Reference:	24/00909/HFUL
Application:	Erection of a bin and bike store with a sedum roof to the front elevation. 38 Frenchs Road Cambridge Cambridgeshire CB4 3LA

Registration of Planning Application

Bin Store

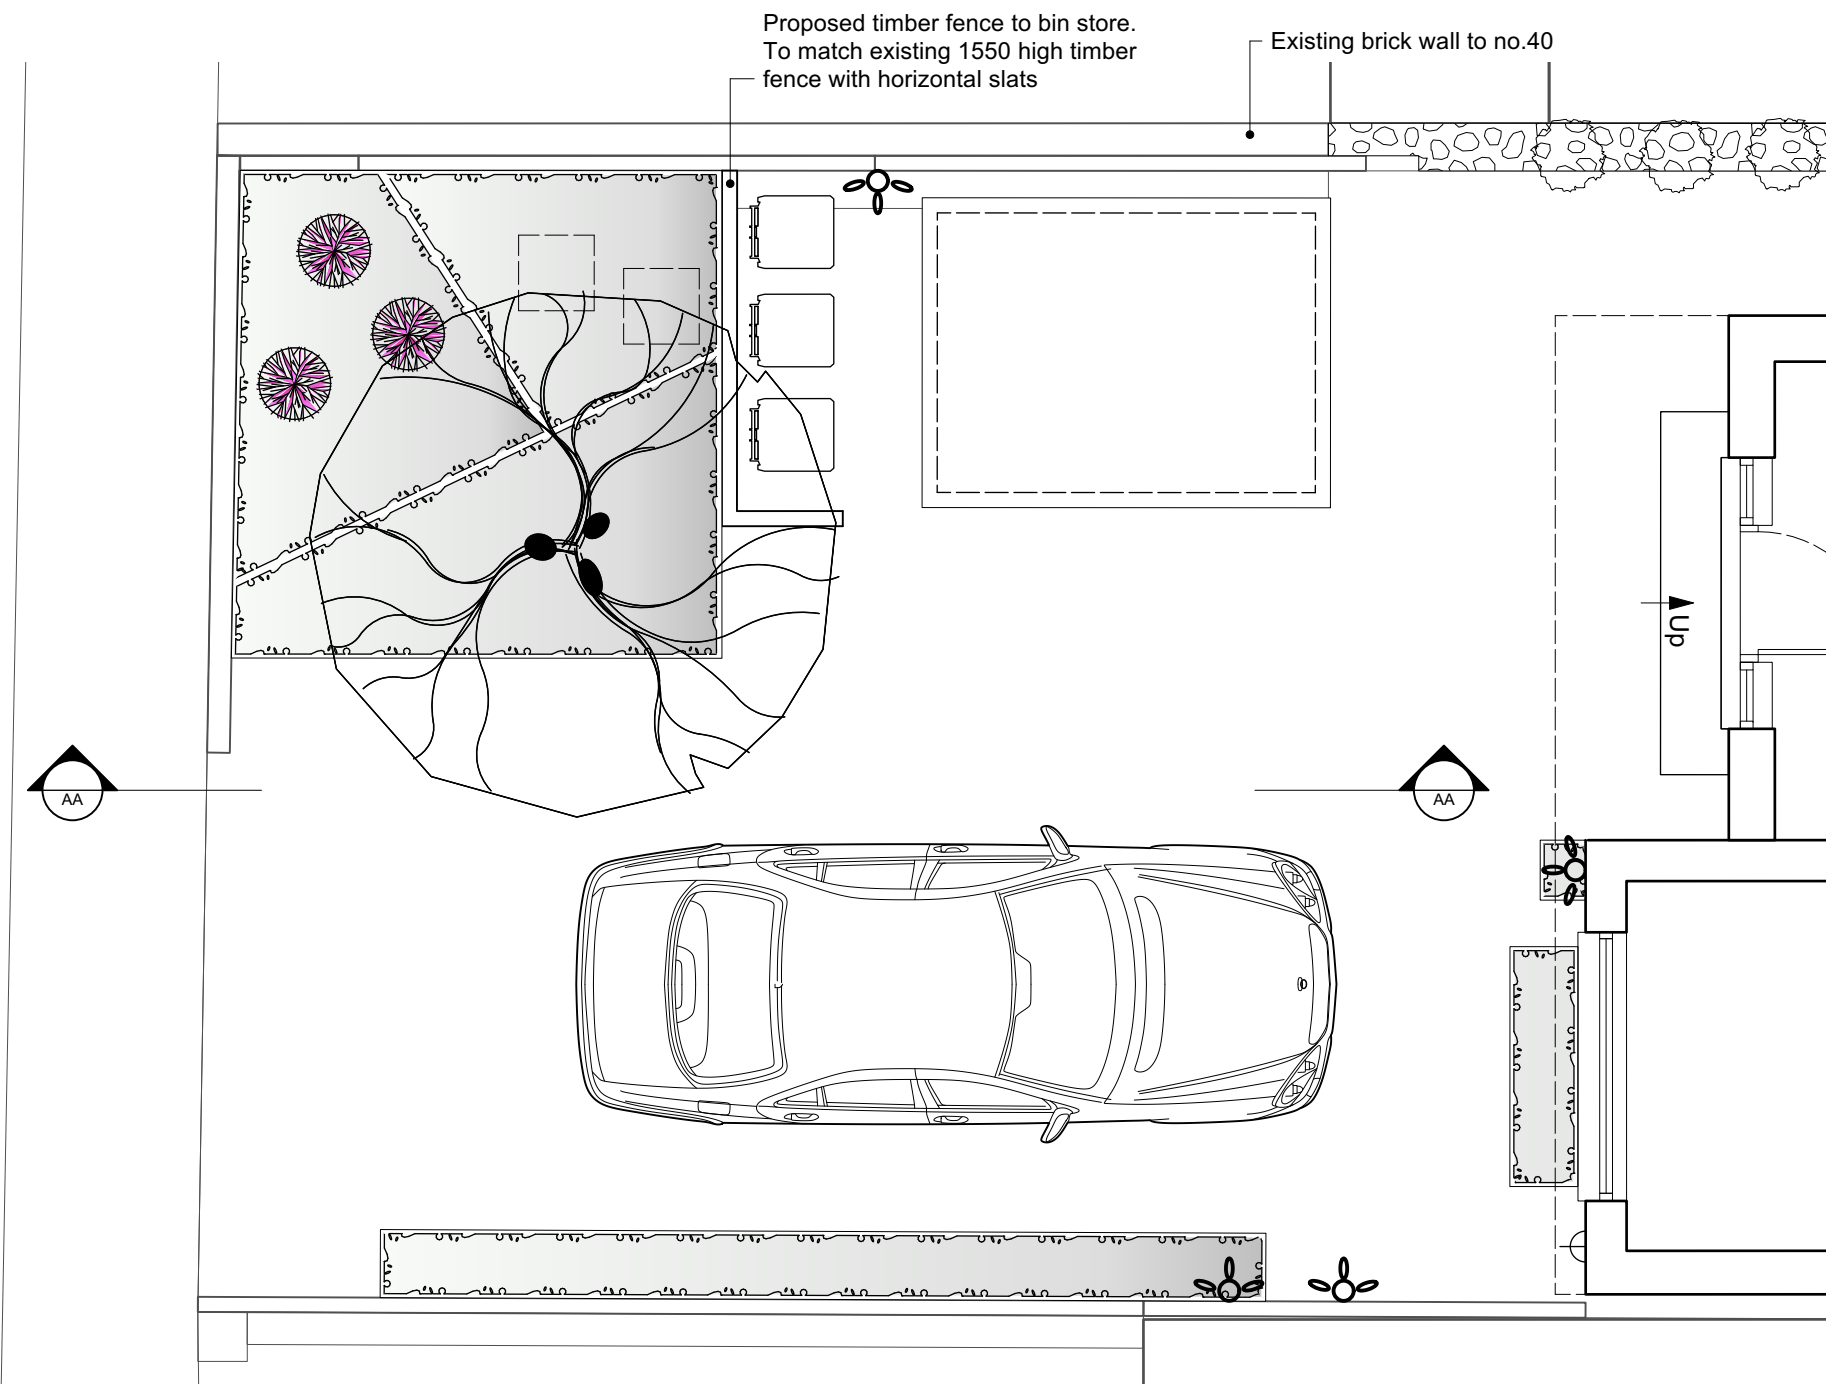
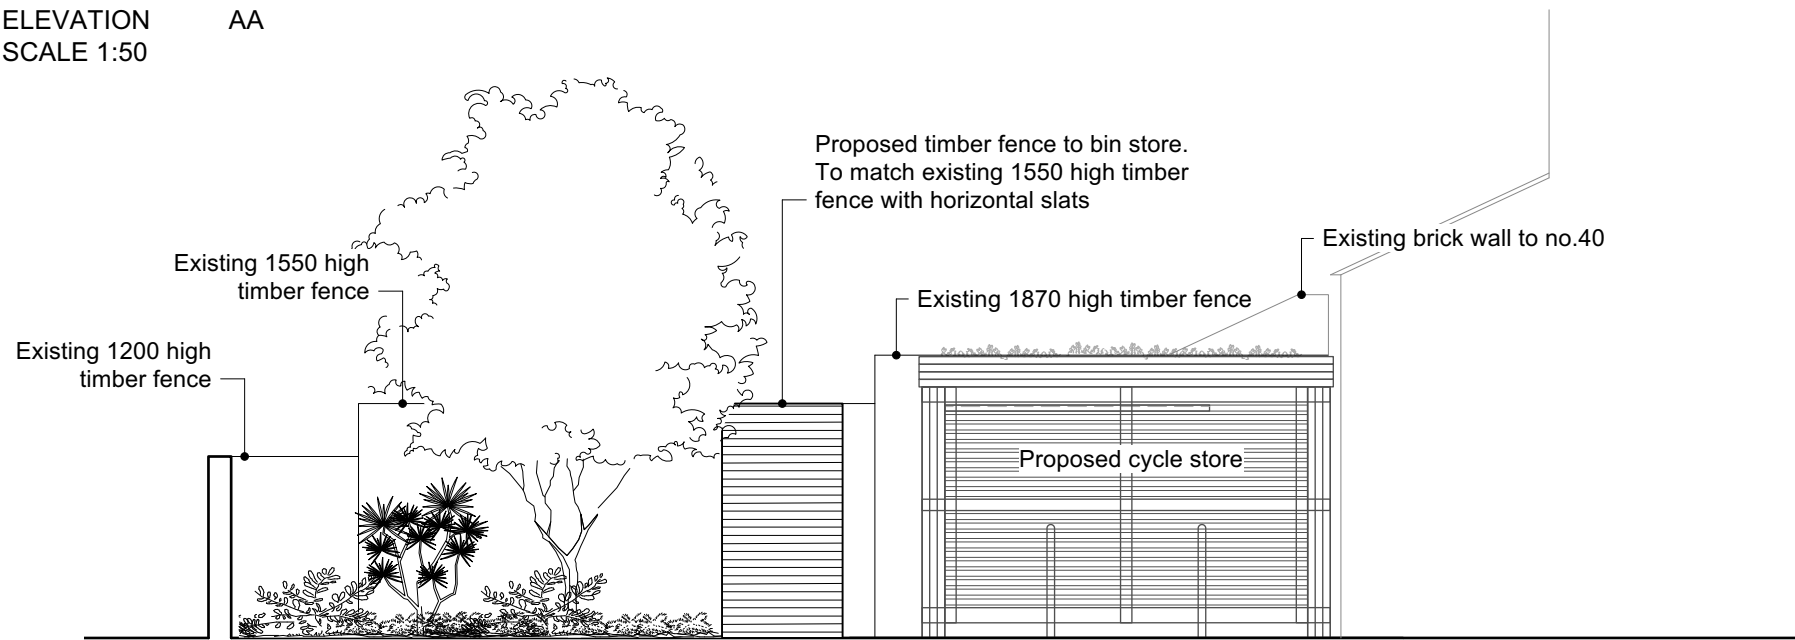
- Please add a scale bar to drawing no 352 bin store.
- Please add a scale bar or measurements to the street elevation
- Please agree to the revised description.
